Application for a non-material amendment following a grant of planning permission.

Number	
Suffix	
Property name	Land East Of Toll Cottage
Address line 1	Lake Lane
Address line 2	
Address line 3	
Town/city	Barnham
Postcode	PO22 0AD
Description of site location must be completed if postcode is not known:	
Easting (x)	496462
Northing (y)	104681
Description

5 No. DWELLINGS COMPRISING 2 No. 4-BED HOUSES, 2 NO. 3-BED HOUSES & 1-No. 3-BED BUNGALOW WITH ACCESS & ANCILLARY WORKS.	
Reference number:	BN/6916/PL
Date of decision	26/04/2107

6. Non-Material Amendment(s) Sought

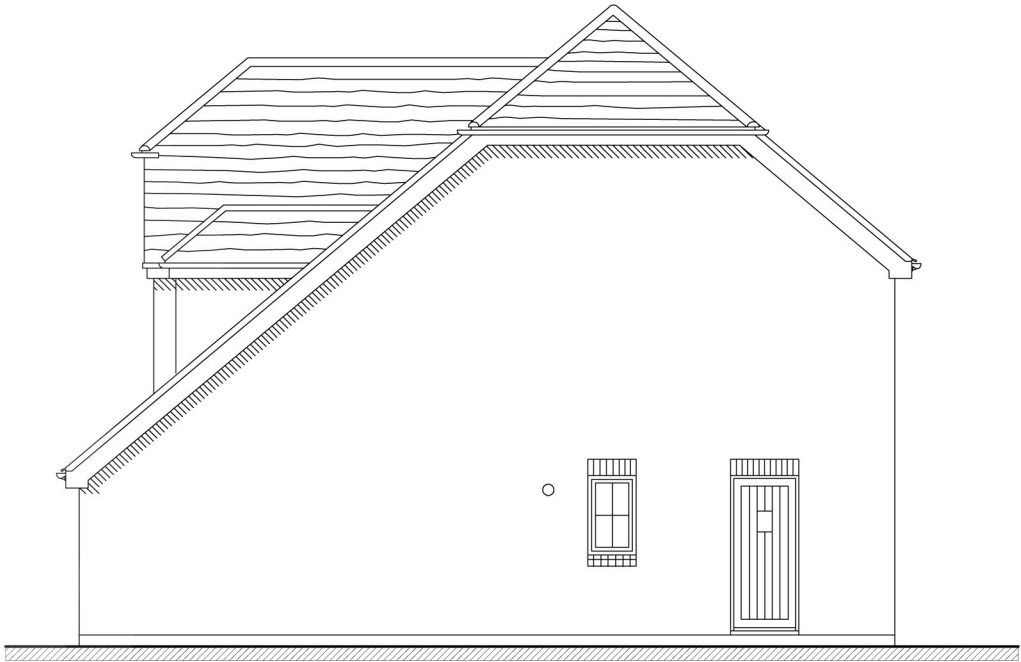
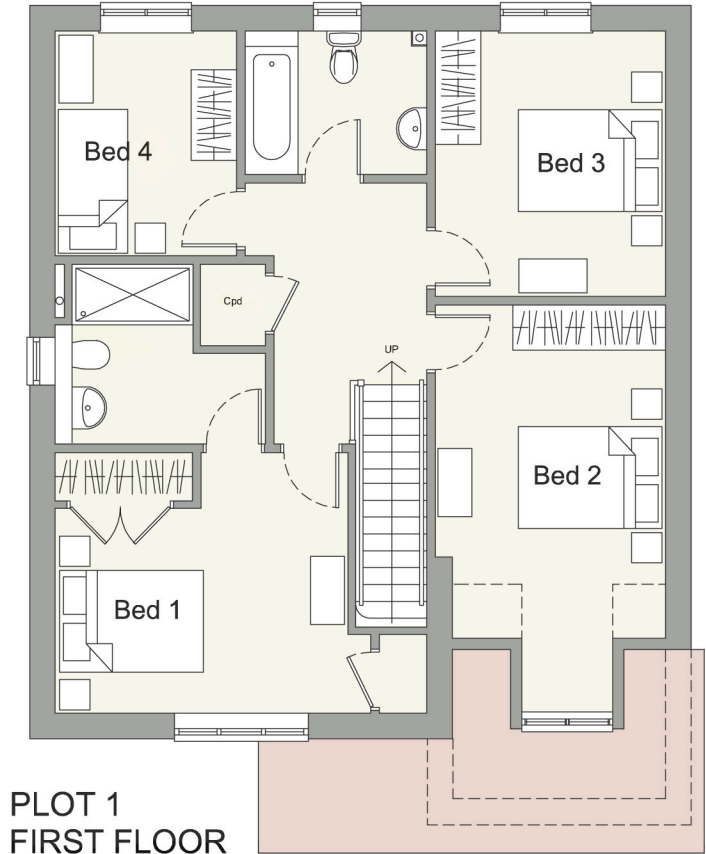
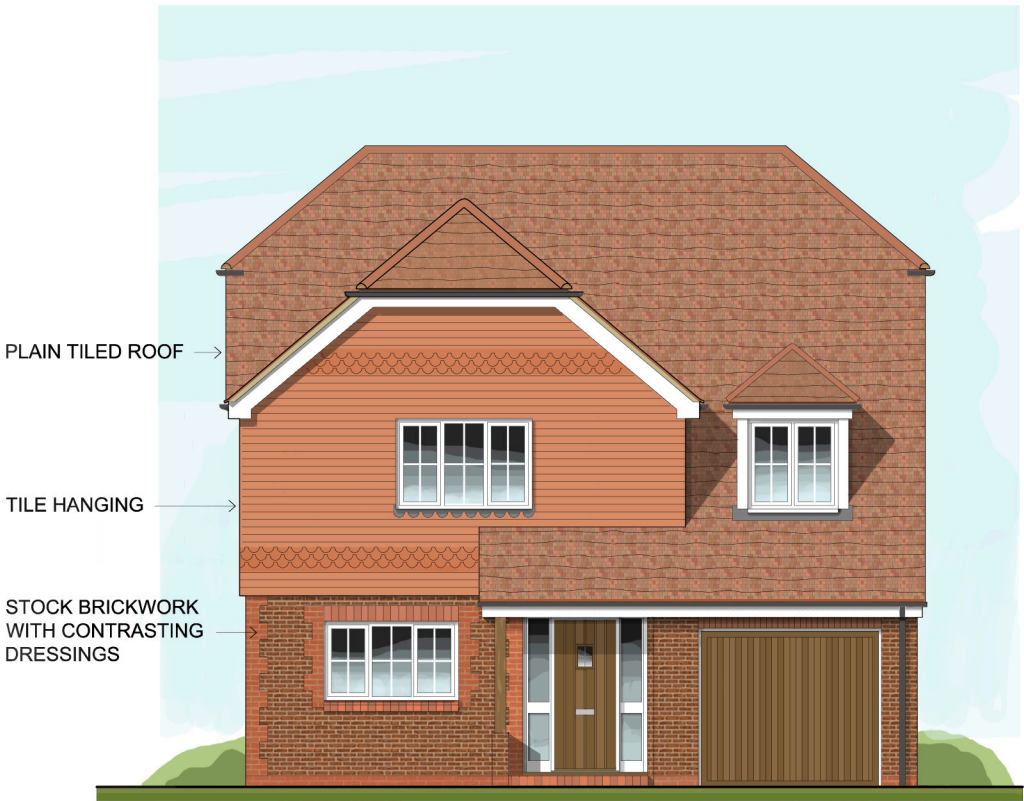
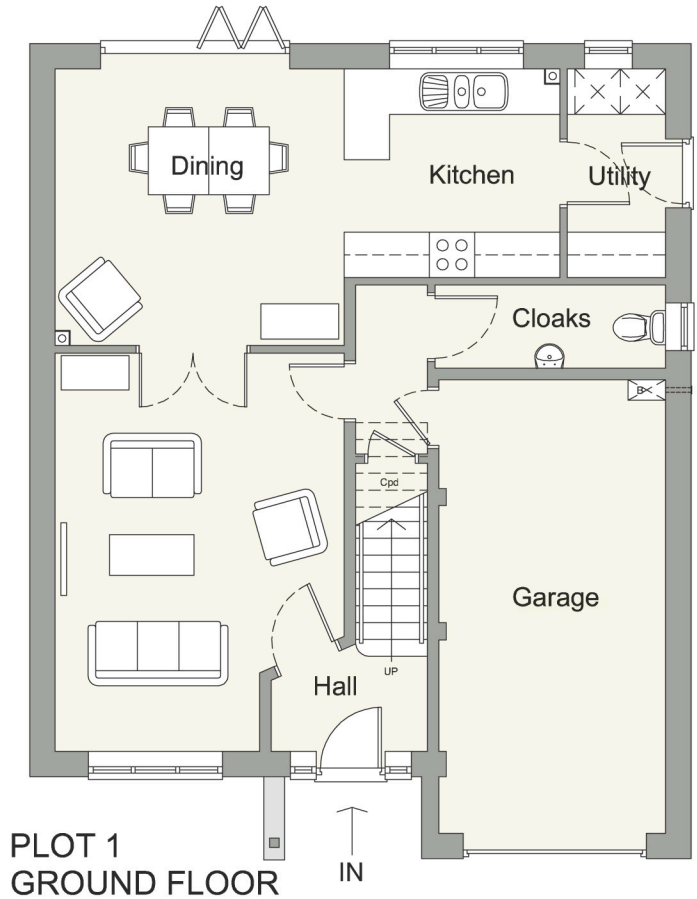
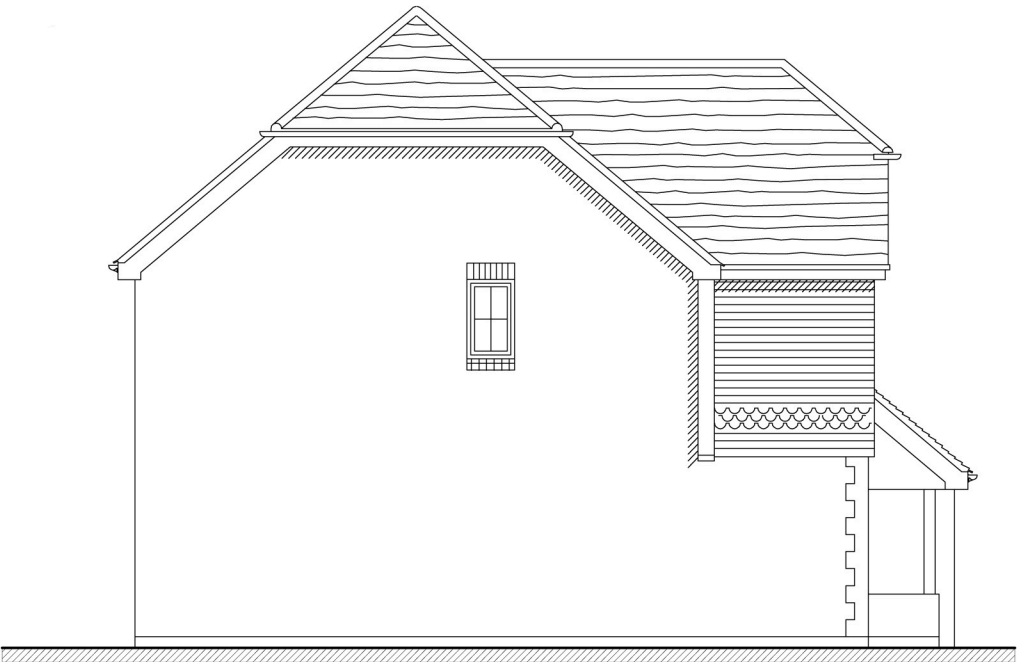
PLOT 1- INTERNAL HOUSE LAYOUT AMENDMENT AND RE-POSITIONED REAR PATIO AREA & OMISSION OF CHIMNEY.

PLOT 2
GROUND FLOOR

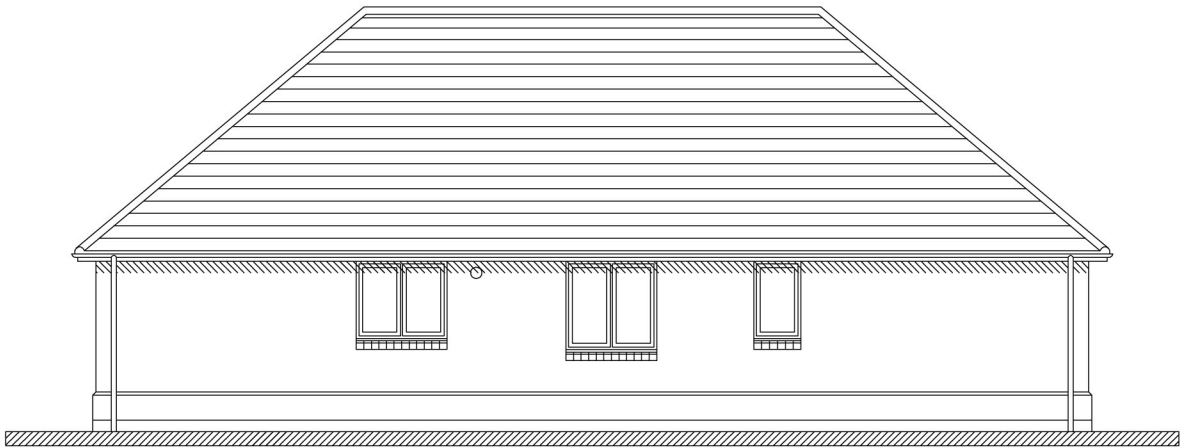
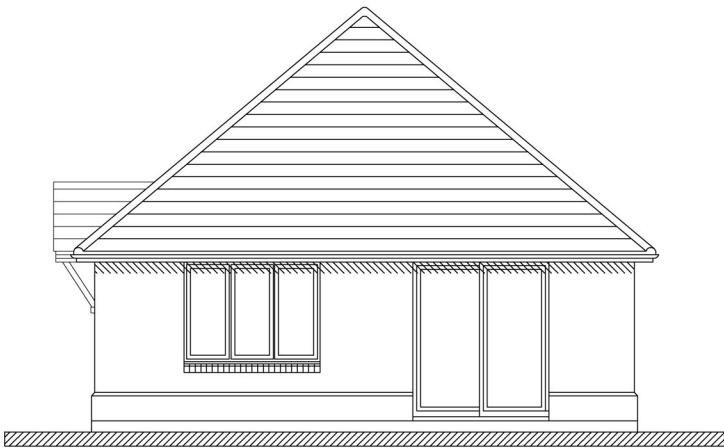
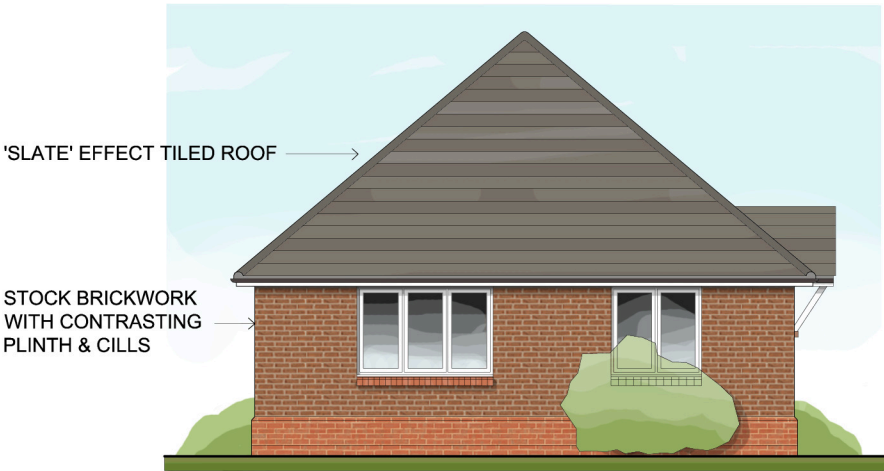
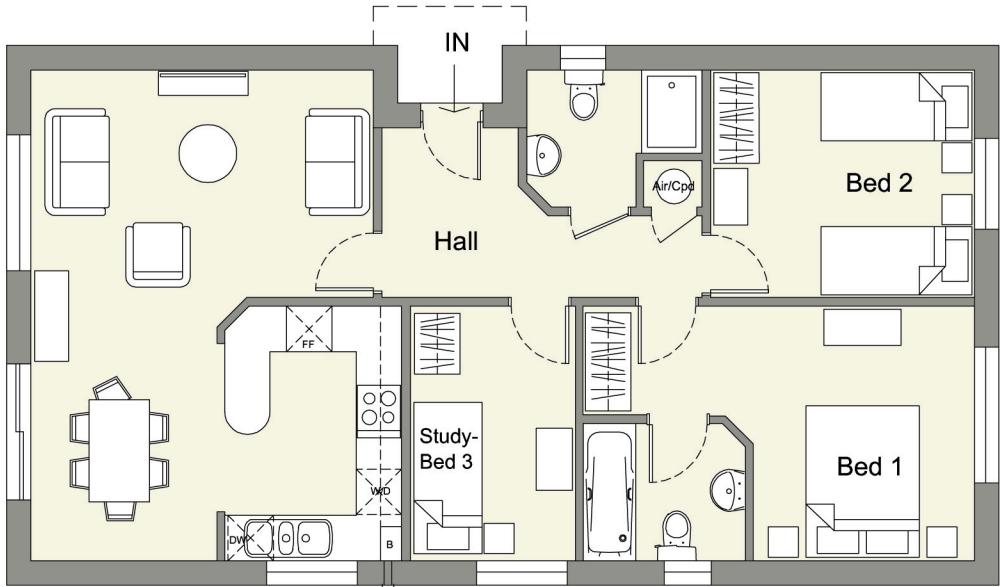
PLOT 2- ADDITION OF A FEATURE ROOF GABLE ABOVE ENTRANCE DOOR, RE-POSITIONED REAR PATIO AREA & ADJUSTMENT OF ADJACENT DRIVEWAY.

PLOT 5
GROUND FLOOR

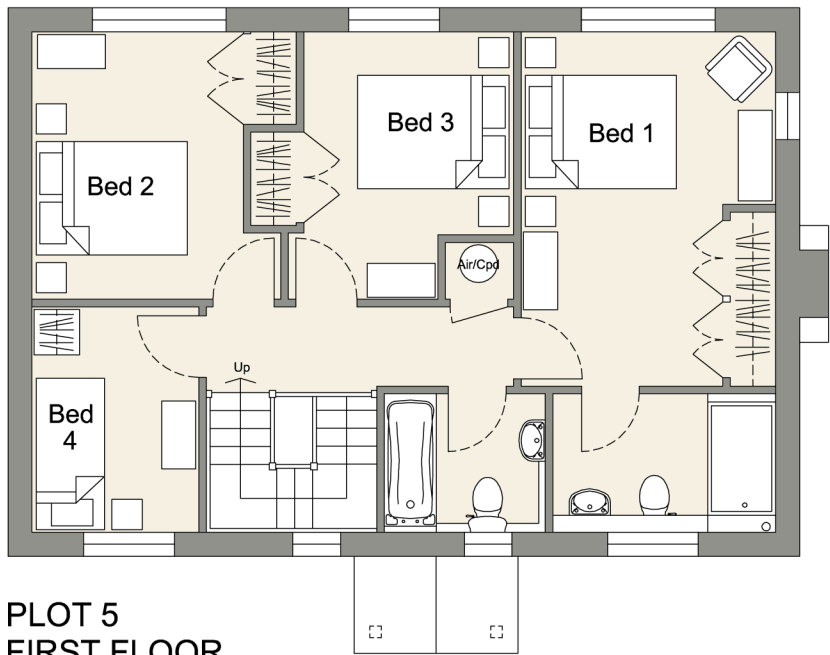
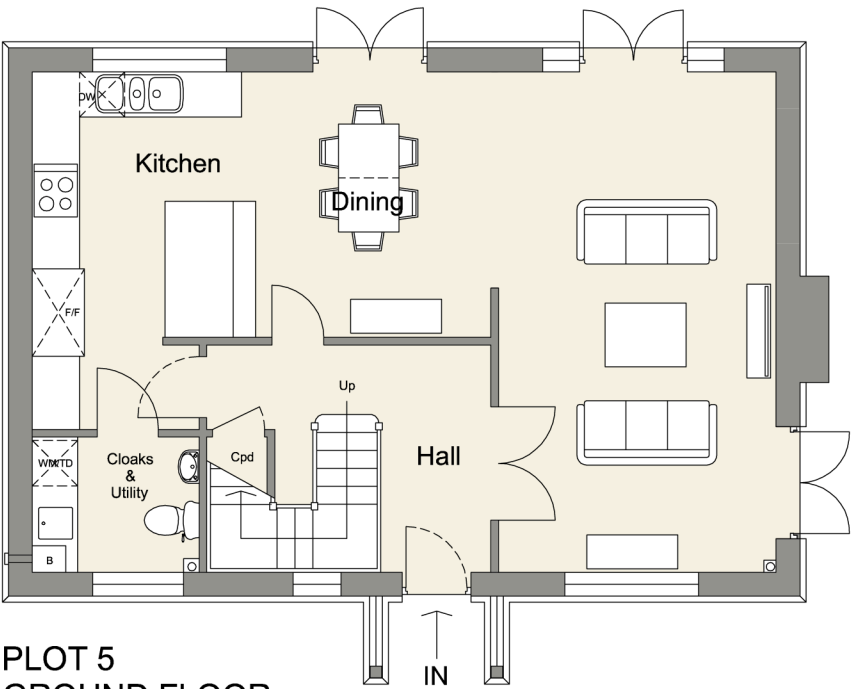
PLOT 5- OMISSION OF BAY WINDOW AND SUBSTITUTION OF FRENCH DOORS TO THE NORTH WEST ELEVATION.
